Reference No:	2022/62/93750/W
Site Address:	479, New Hey Road, Salendine Nook, Huddersfield, HD3 3XG
Description:	Erection of a rear dormer and a single storey rear & side extension with disabled ramp.
Recommending Officer:	Sam Jackman

DECISION – Conditional Full Permission

Officer Report – 2022/93750

Drawing Title:
Proposed Layout

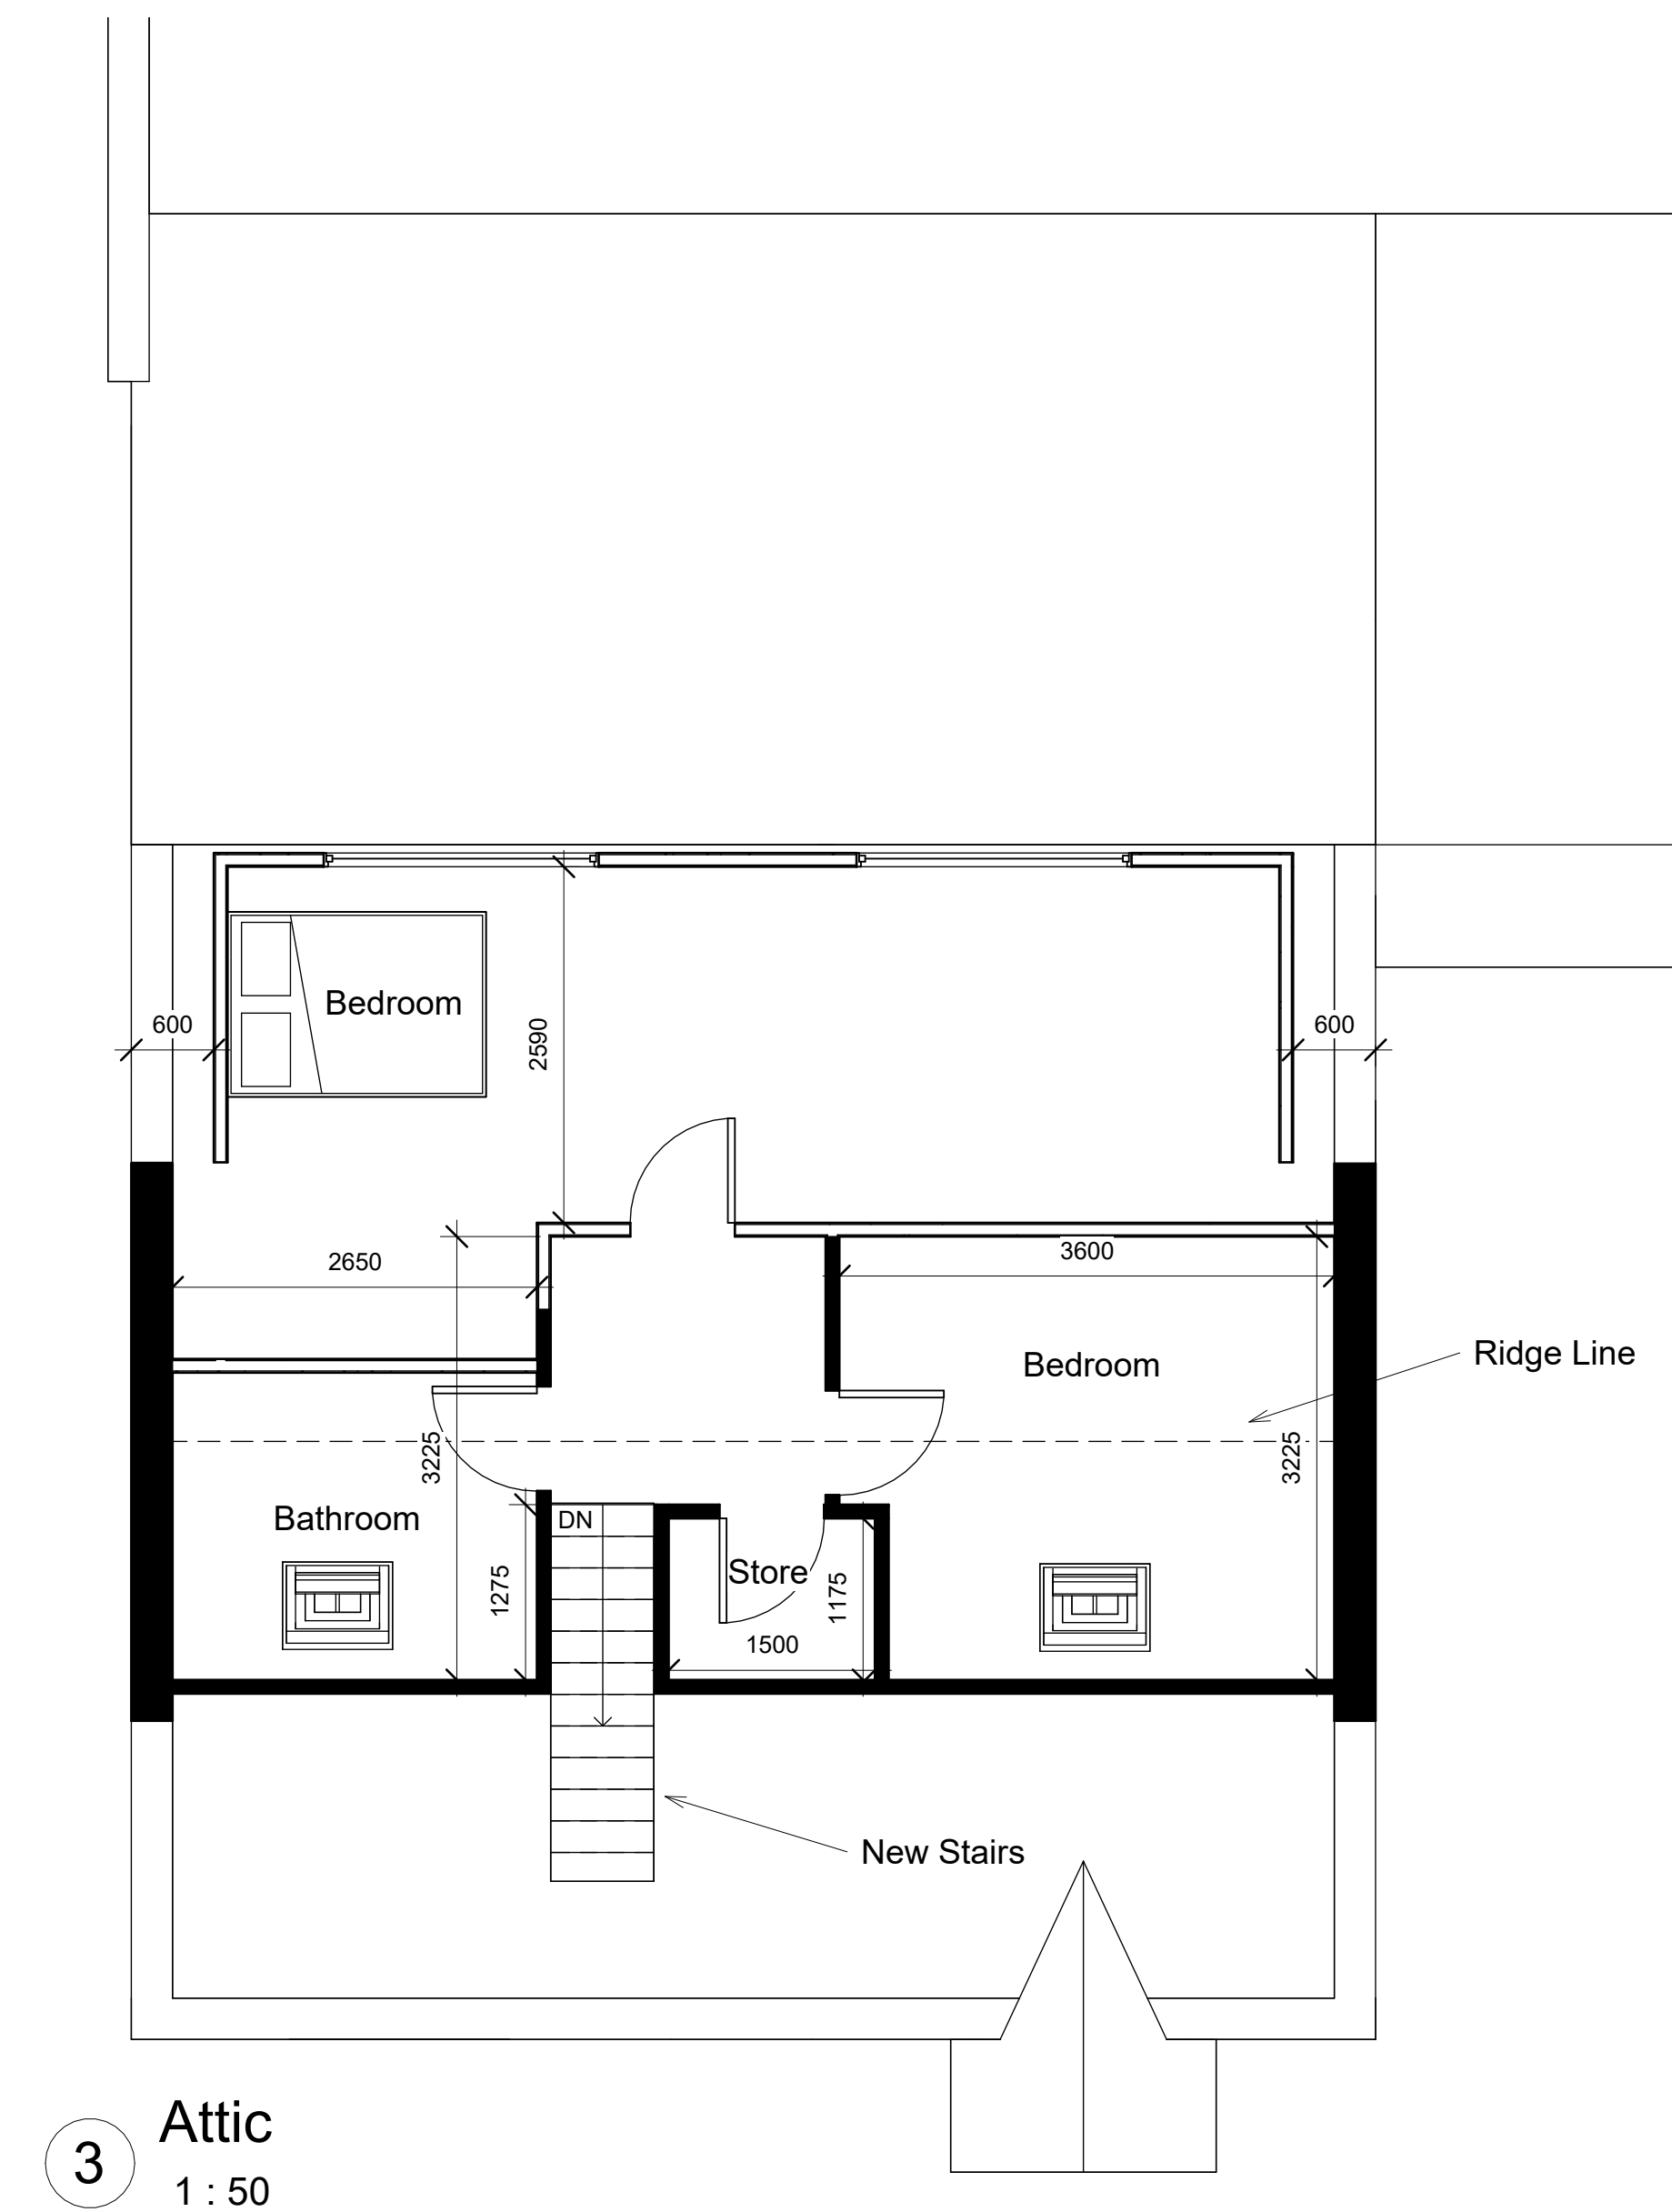
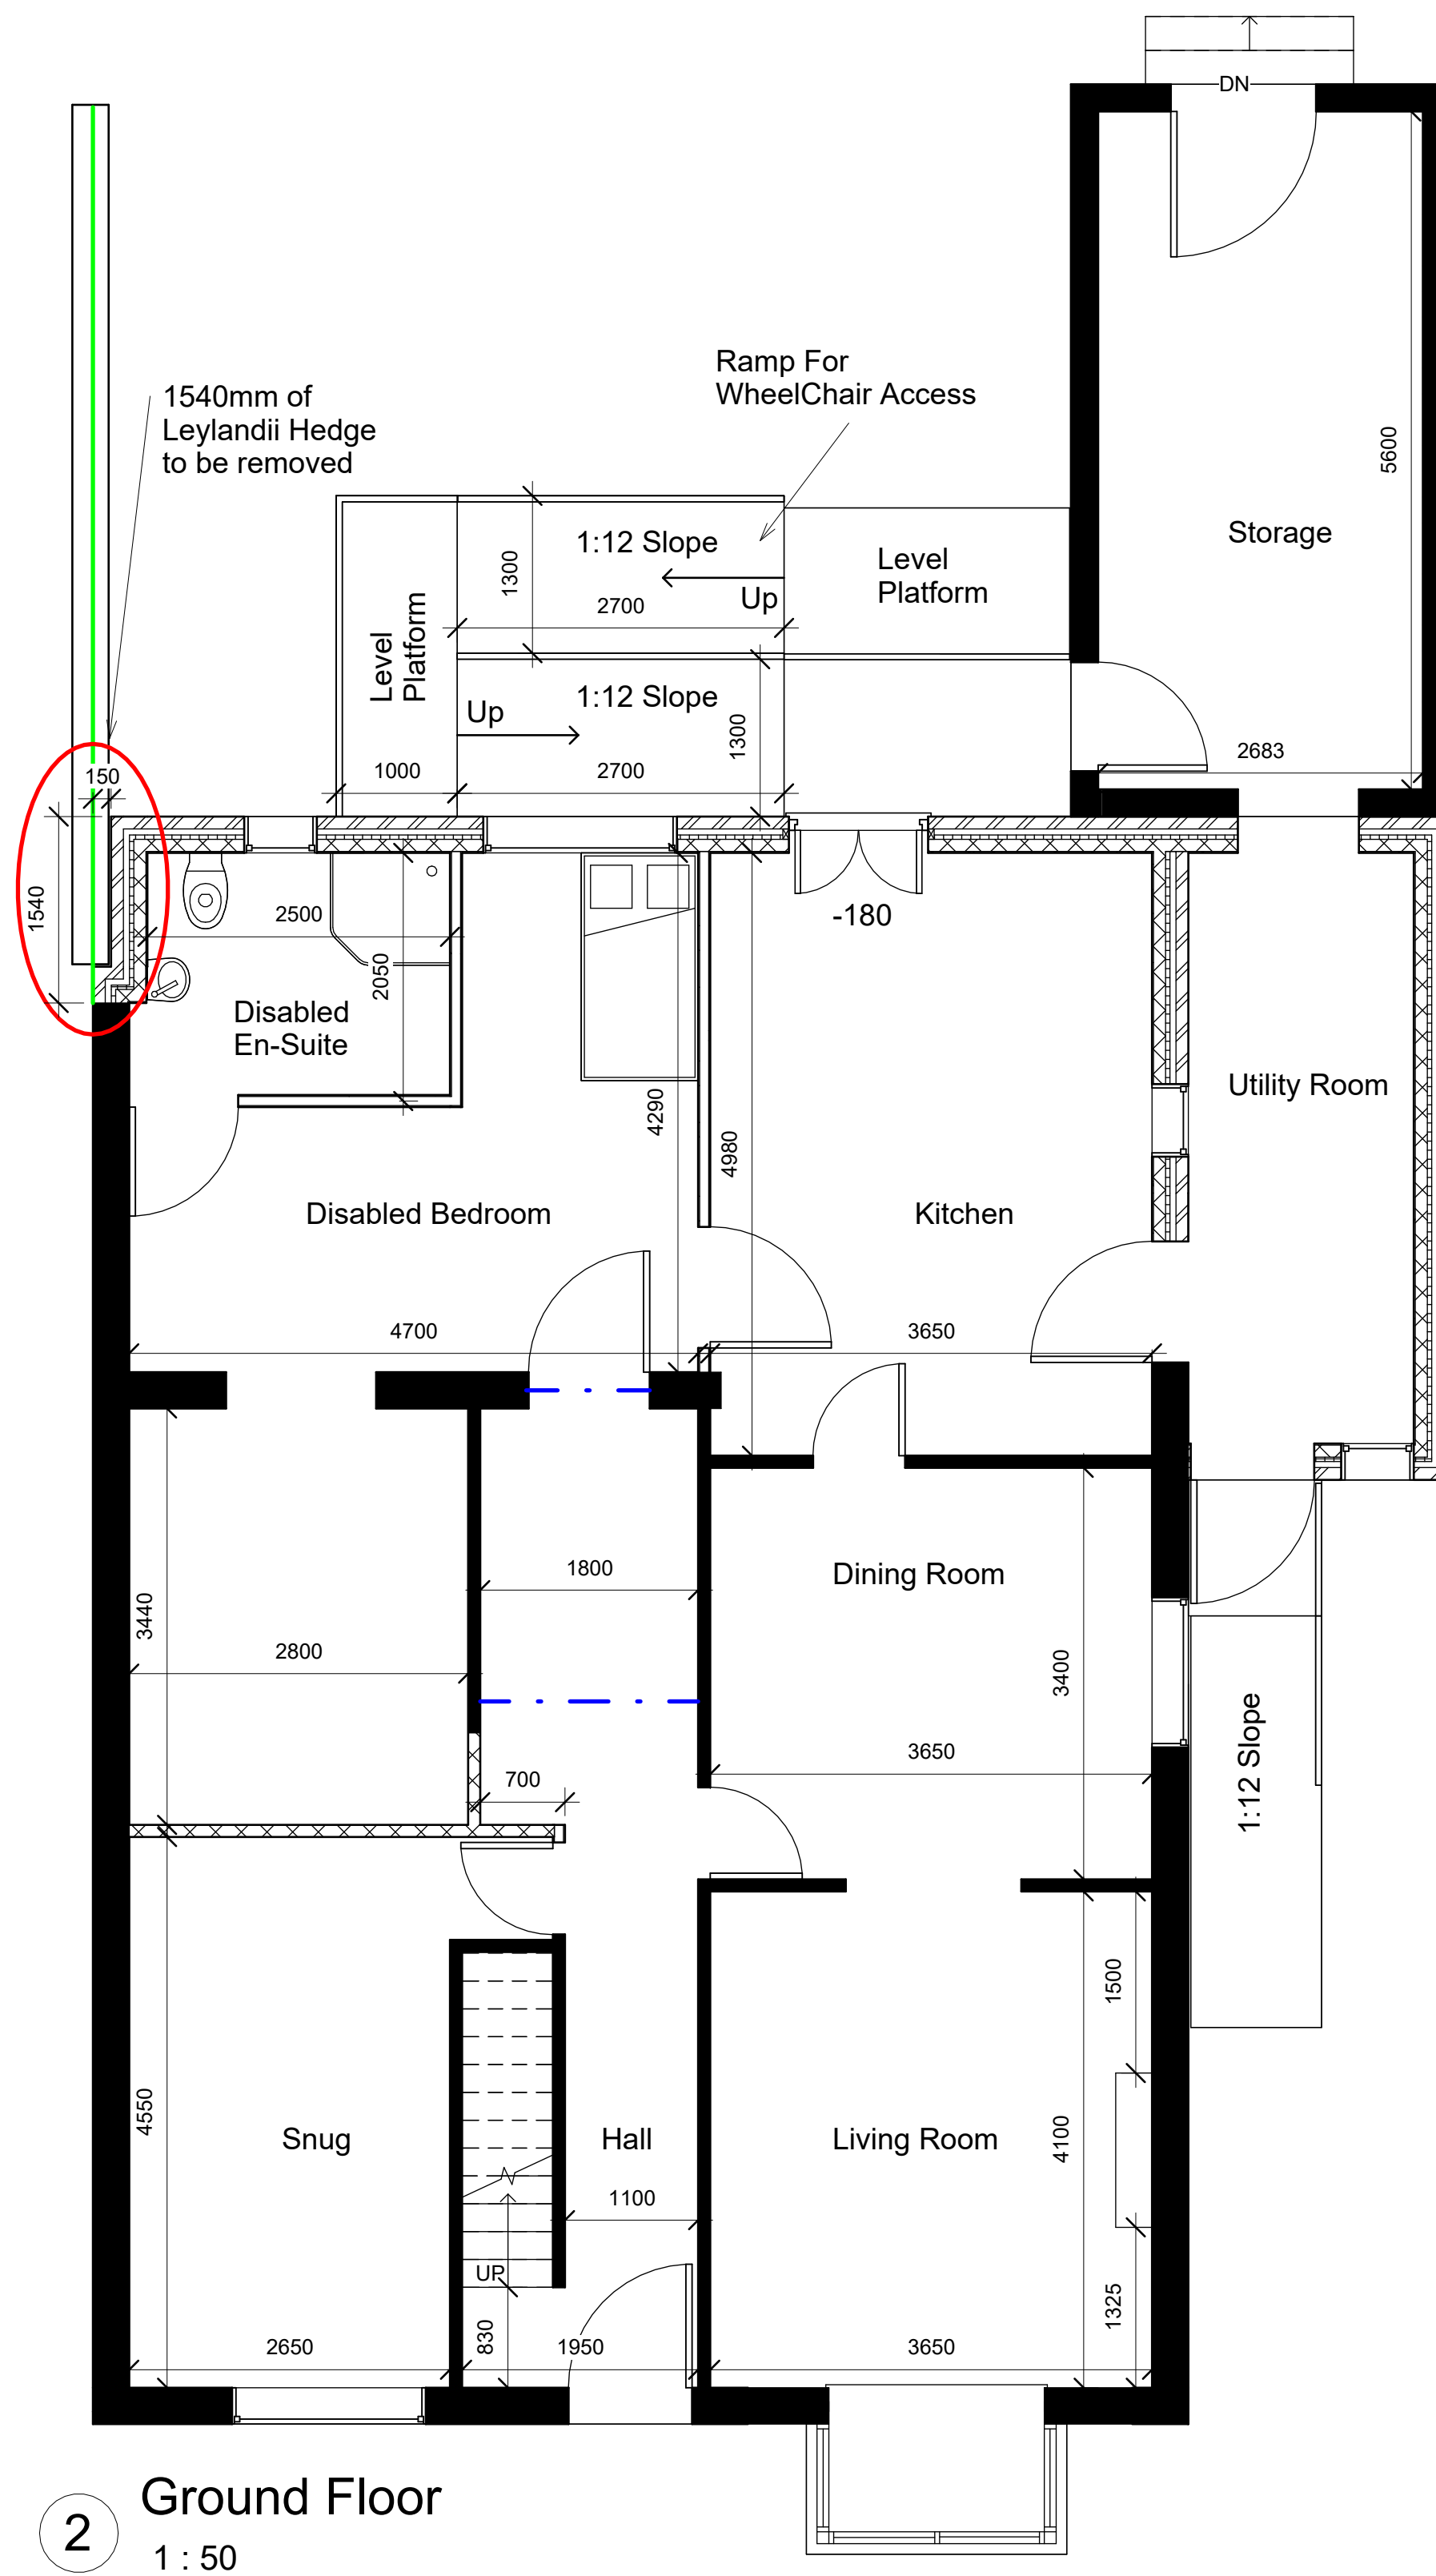
- The existing wall for the conservatory will be retained on the boundary with No. 477 and the extension will then be set in 0.15m for the remaining 1.54m, where the existing hedge will be removed retaining the remainder.

Further amendments have been received to replace the flat roof over the utility with an asymmetrical dual pitched roof, the eaves lowered for the rear elevation and the disabled ramp having clear top & bottom platform areas, along with steps shown from the rear elevation of the existing storeroom.
